From: Anita Gardner
Sent: 23 January 2019 14:23
To: Planning.Responses
Subject: FW: FG/196/18/PL - Replacement Dwelling - 12 West Drive, Ferring
Attachments: 2919-02 revH Proposed Floor Plans Elevations.pdf

From: Anita Gardner <[REDACTED]>
Sent: 08 January 2019 11:30
To: 'kennyfoxwell@horizon-design.co.uk' <[REDACTED]>
Subject: FW: FG/196/18/PL - Replacement Dwelling - 12 West Drive, Ferring

Proposed Rear (west) Elevation
Scale 1:100

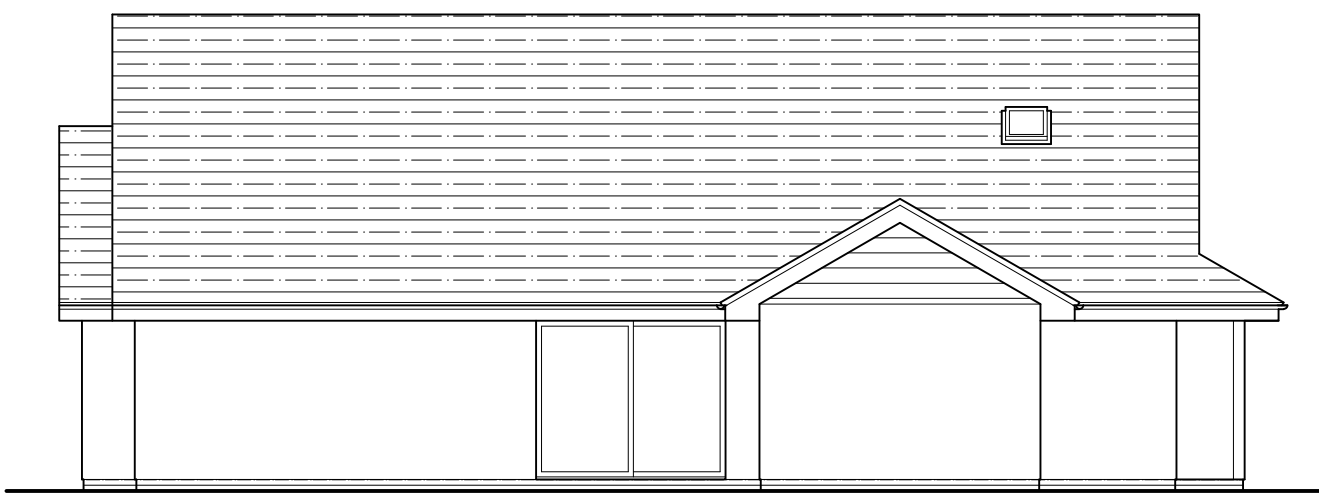
Thank you for your email, and voicemail message clarifying the reasons for your colleagues' concerns. I have spoken to my clients about this, and they're not happy with removing the rear facing window. They would like to point out that the property immediately to the south, 14 West Drive, has a rear facing first floor window which received planning permission as part of a loft conversion, with a similar depth garden. We also note that there are rear-facing first floor windows to three properties further south, at 20, 22 and 24 West Drive. All of these properties appear at least as close, if not closer, to their rear neighbours than the application property.

The application has been looked at by my Team Leader who has discussed it with the Service Head. He has not signed off my recommendation to approve and has requested that the rear attic window is replaced with roof lights. Accordingly, I would appreciate receipt of revised plans within the next 10 days and would appreciate your agreement to an extension of time on the application until 23-01-2019 to accommodate this.

I also have a minor revision to the plan; we have added a small veranda to the rear of the lounge, please see attached drawing. It will comprise timber posts with a small hipped roof made continuous with the existing roof, with materials to match. Is it too late to add this to the application? Please let me know your thoughts.
